Mountain Splendor Services Contractor Equipment Yard & Office, VA-19-008

Please accept the following comments from El Paso County Public Health for the project referenced above:

SITE DEVELOPMENT PLAN

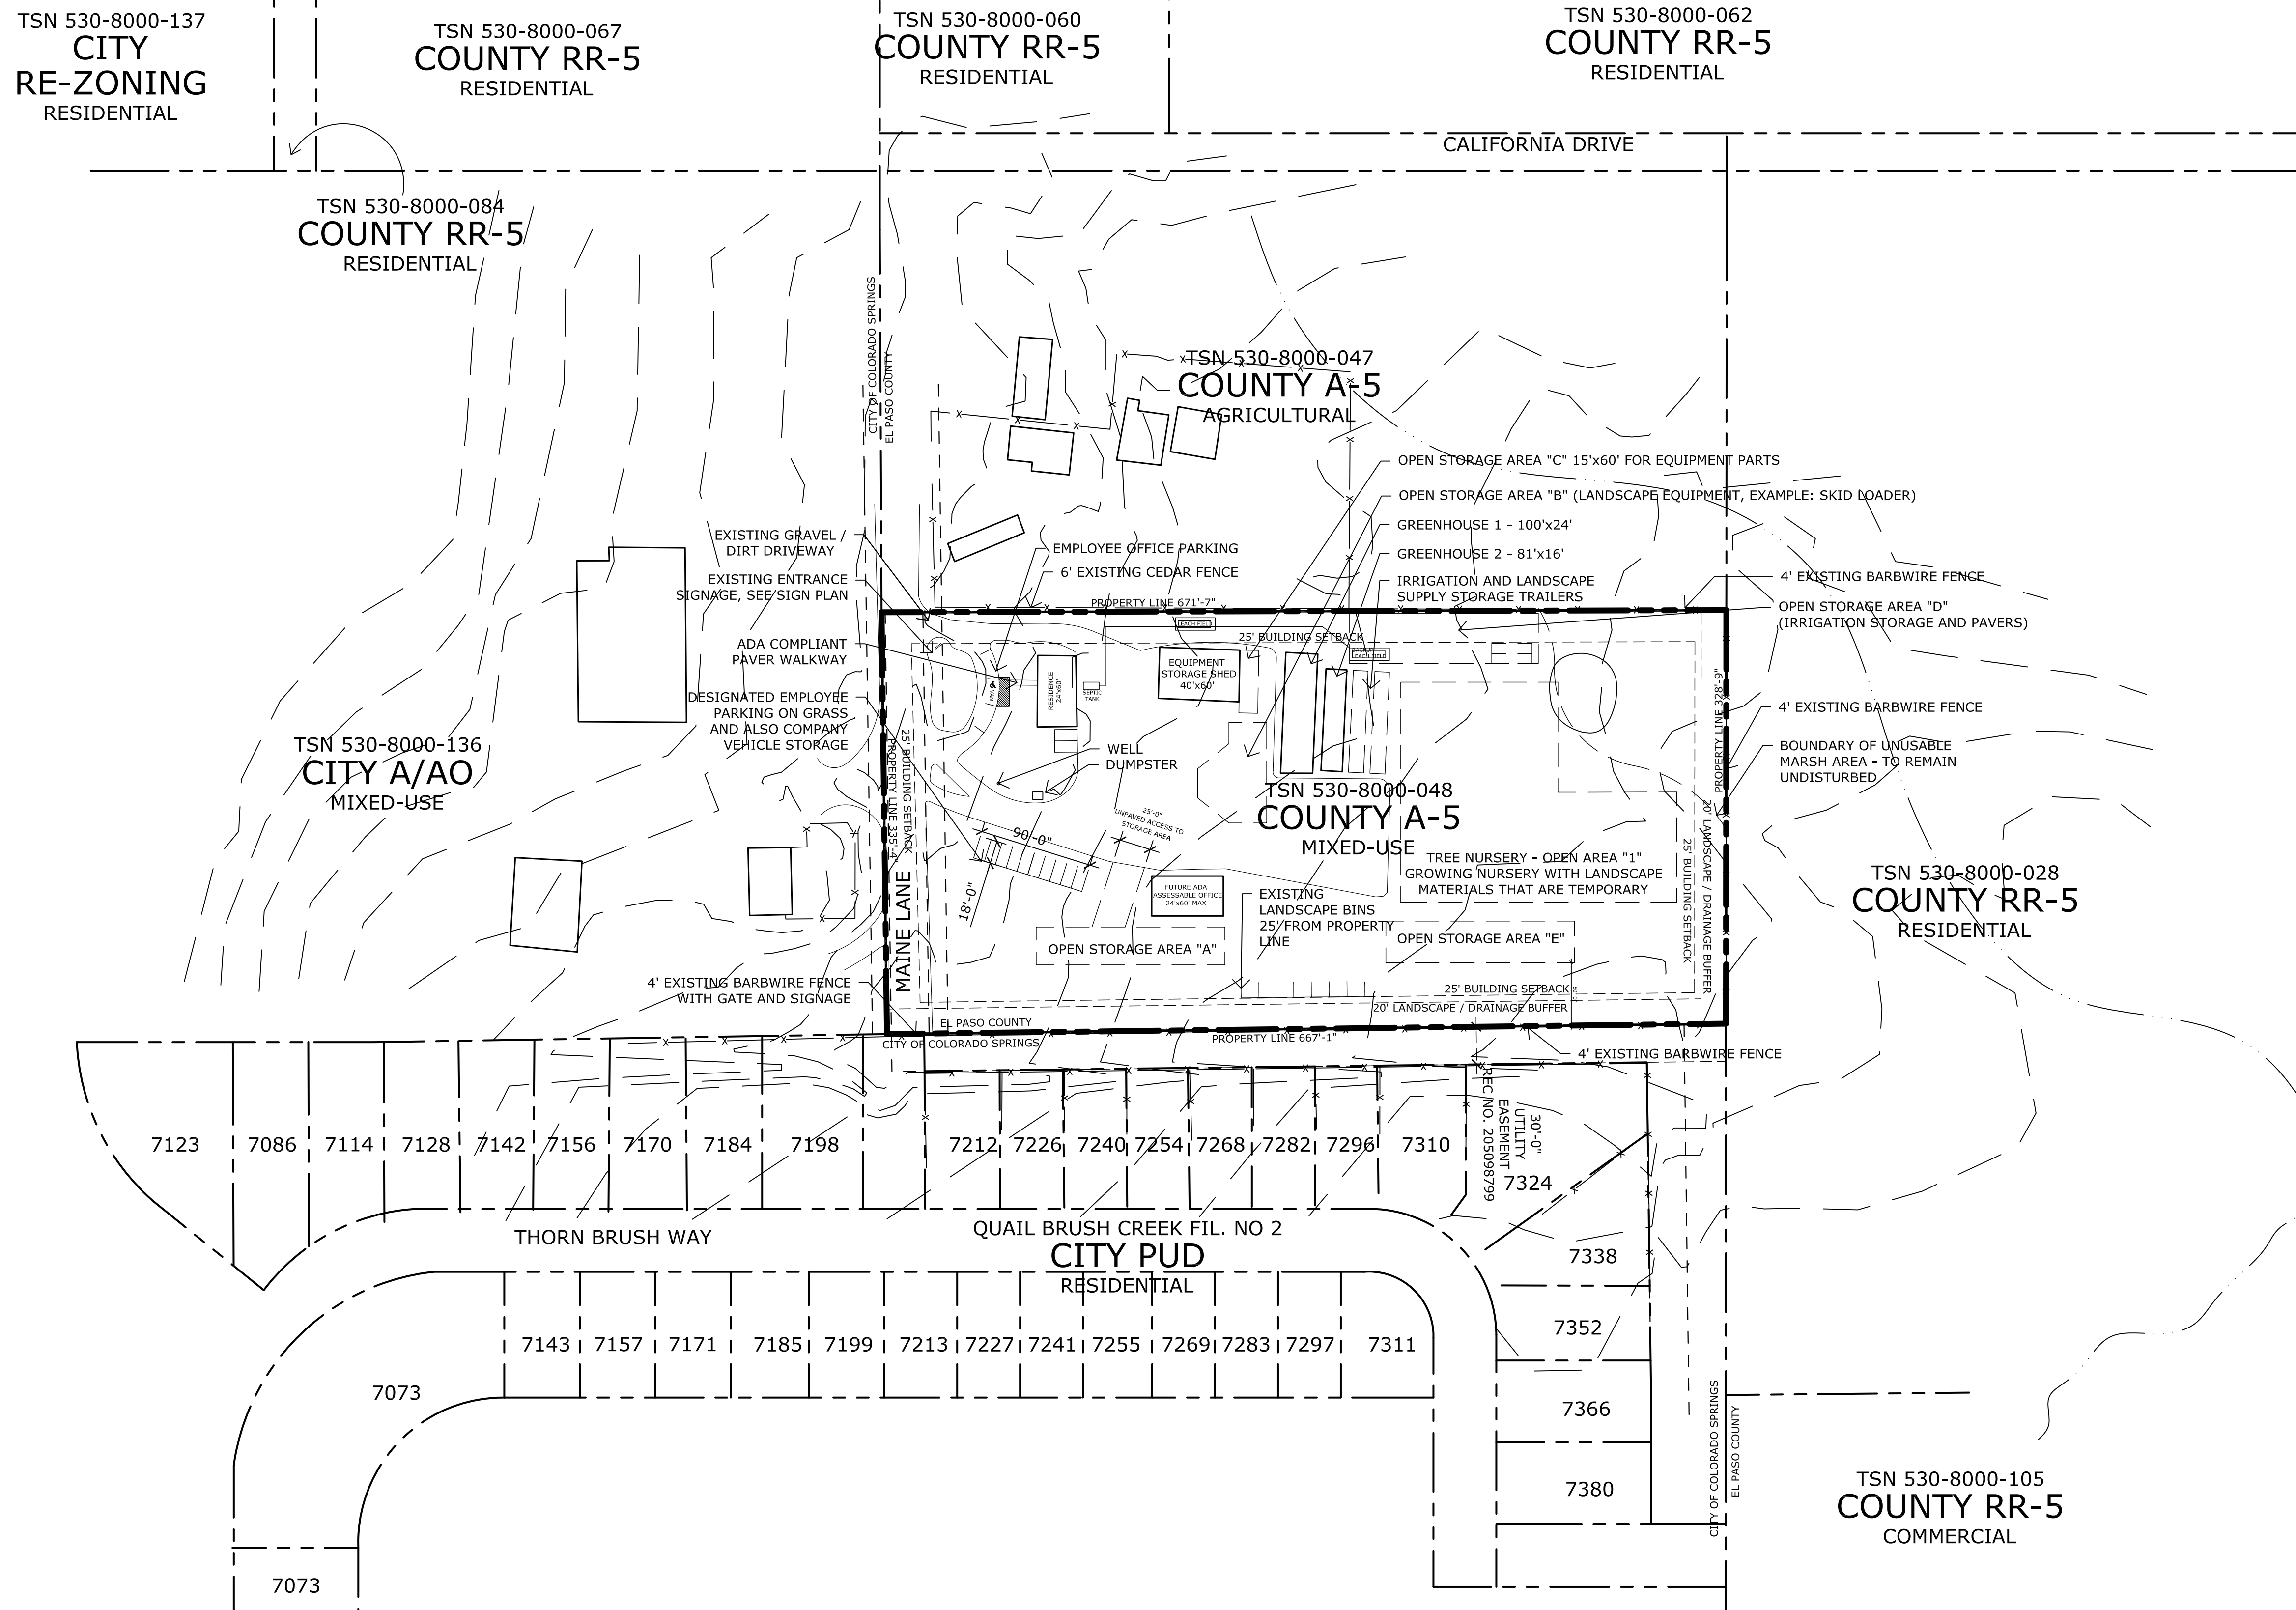
- The permitted and approved onsite wastewater treatment system (OWTS) was installed in 1988 and sized for a 3 bedroom house. The soil treatment area (STA) is located south and east of the house/office but is not identified on the site plan as requested in 2018. A map of the OWTS components is available on the El Paso County Assessor's Office website: <http://www.land.elpasoco.com/default.aspx>
- The existing primary STA must be located, and traffic control measures must be taken to protect it from compaction by vehicular traffic. There must be an equally sized secondary STA site identified and protected from compaction that meets the 100' setback from the existing well. This secondary site is required in the event that the primary site was to require repair or replacement.
